Re Exhibition of SSD 15 7317 for Australian Technology Park (ATP)

I write to raise objections to the above development application on behalf of REDWatch the community group monitoring the suburbs of Redfern, Eveleigh, Darlington and Waterloo (REDW). A range of issues have been raised with us by our members and community members regarding this development which falls within our area.

Figure 9 – Building 1 (foreground in white) and Building 2 (background in white)
 Source: FJMT + SISSONS Architects

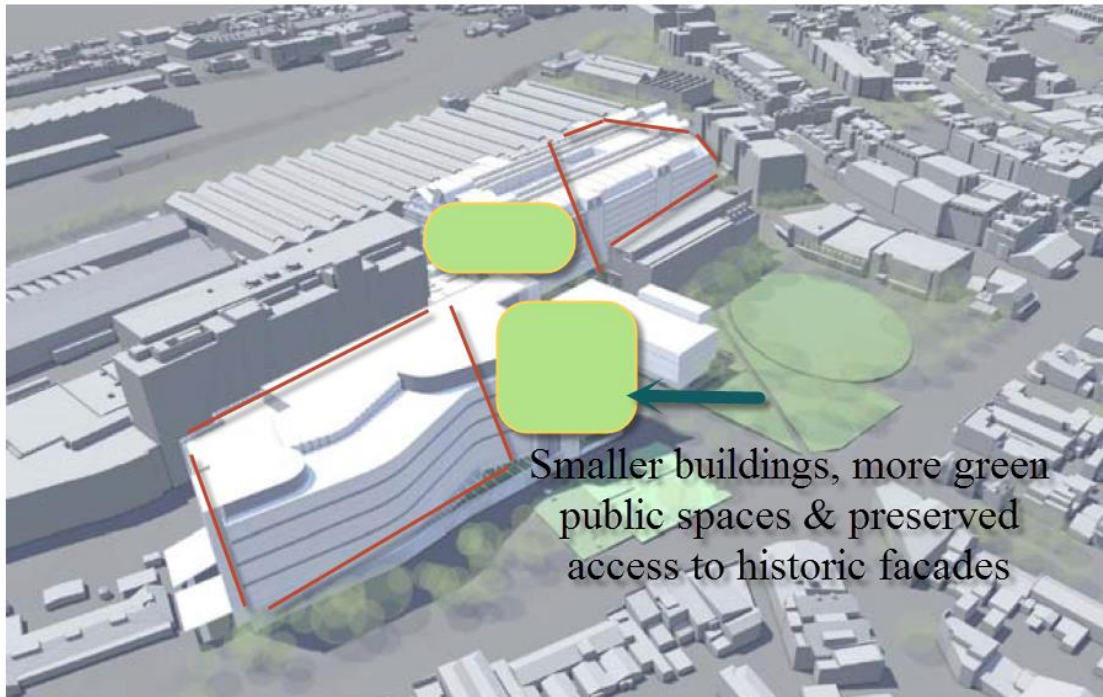
The increase on Building 1 helps to contribute to the height variation request to place a higher building into the 4 storey zoned area near the pre-school. REDWatch opposes this extra floor space and requests it be removed from the area where building 1 exceeds the planning controls.

REDWatch is also very concerned about 35% GFA increase in Building 2 and opposes this increase. The proponent has chosen not to use the height allowable of 9 and 11 storeys on the site but rather to make the floor plates cover almost all the available site and then to increase the floor space by in excess of 1/3 again to achieve 7 storeys across the site. This approach results in the greatest possible hiding of the heritage Locomotive Workshops and destroys any possible vistas of the heritage site that would be possible from a lesser footprint.

For example, removing around a quarter of the proposed building land coverage in Building 2 that results from the relocation floorspace to the site, could be used to open up the vista of the Locomotive Workshops from between Channel 7 and Building 2. It could also be used to increase the separation between the Locomotive Workshop and building 2 or opening up of the view of the Locomotive Workshops from the walkway between the Biomed Building and Innovation Plaza. This could be done by removing the tapering along this walkway and would be further improved if the tapering created the shortest side to the north rather than the south.

Figure 2 – Illustration of height distribution across ATP (with proposed variation circled in red)
Source: *fjmt*

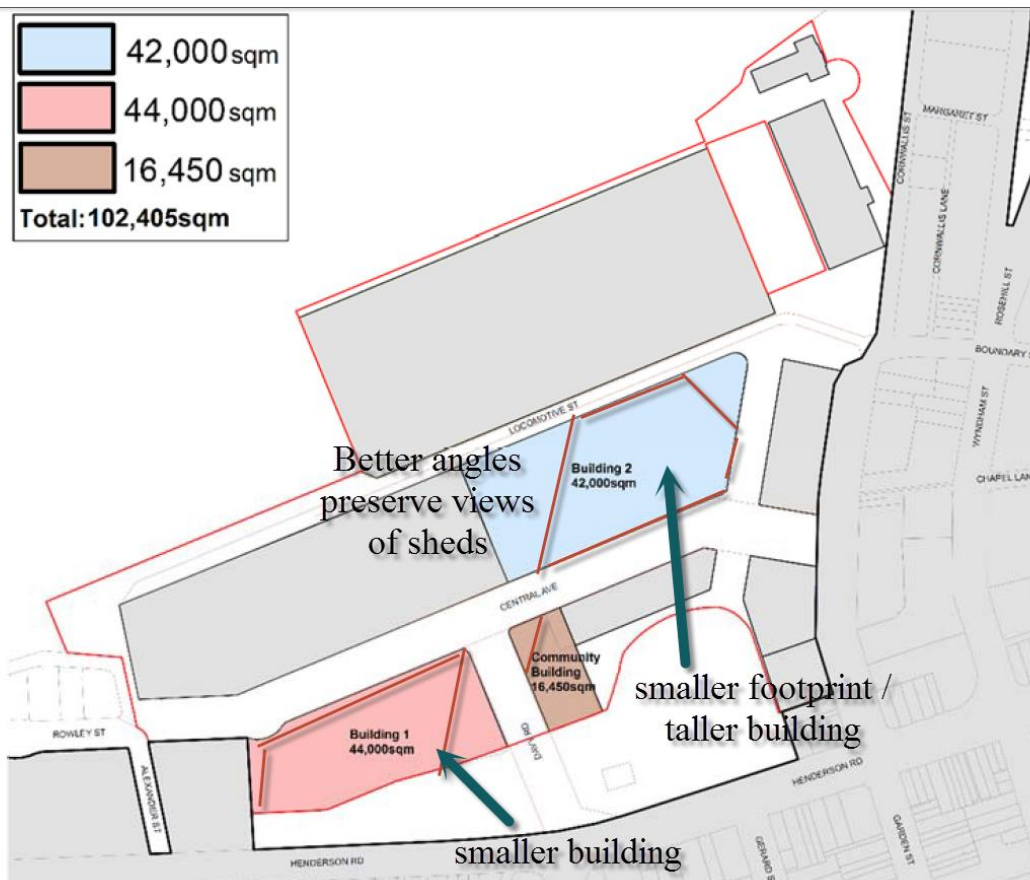
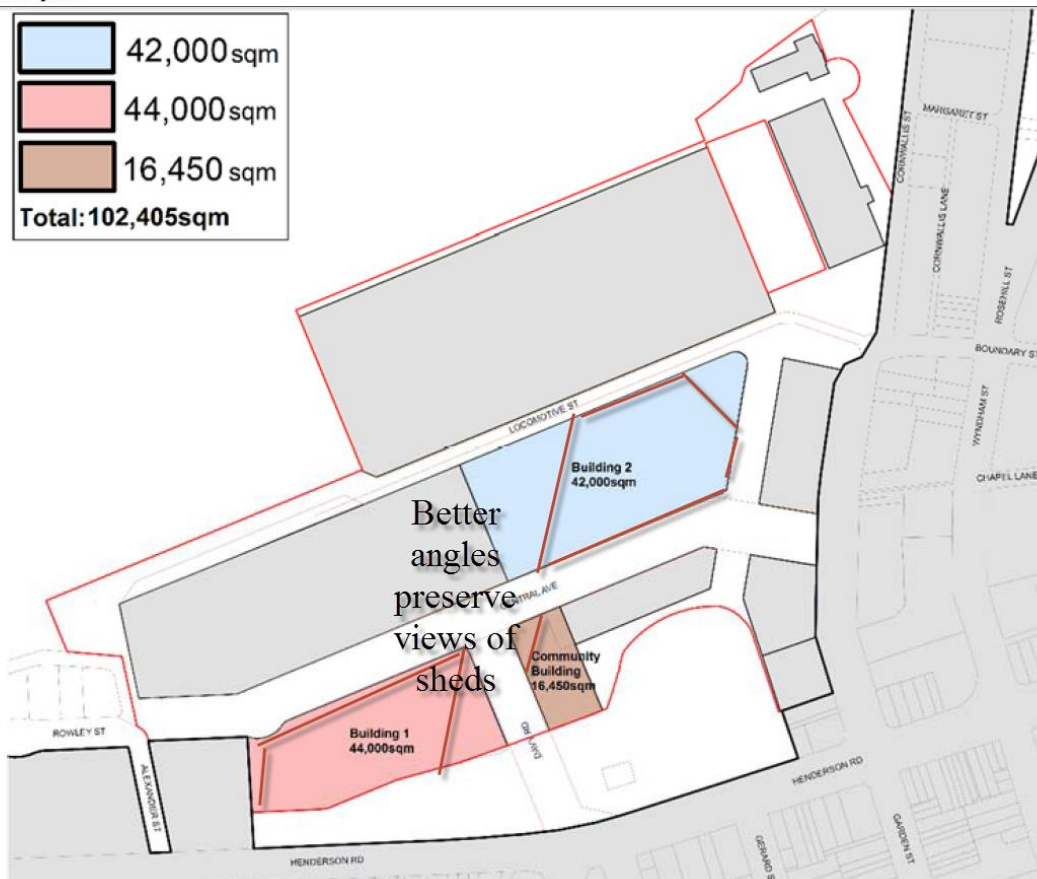
- i) Opposition to height variation on Building 1 – The proponent requests a height variation in the proximity of the existing Alexandria child care centre which the proponent's land directly abuts. The planning height controls step down towards the pre-school and the adjacent residential area. The extra height sought is in close proximity to the pre-existing childcare facility and the variation will directly adversely impact upon the childcare centre and its solar access.

REDWatch submits that the current planning controls exist, albeit somewhat imperfectly, to protect the child care centre and hence the variation should not be allowed. REDWatch also notes in the next section that the height breach is also associated with an over allocation of GFA to the site. The extra GFA should be removed from the area subject to the height breach.
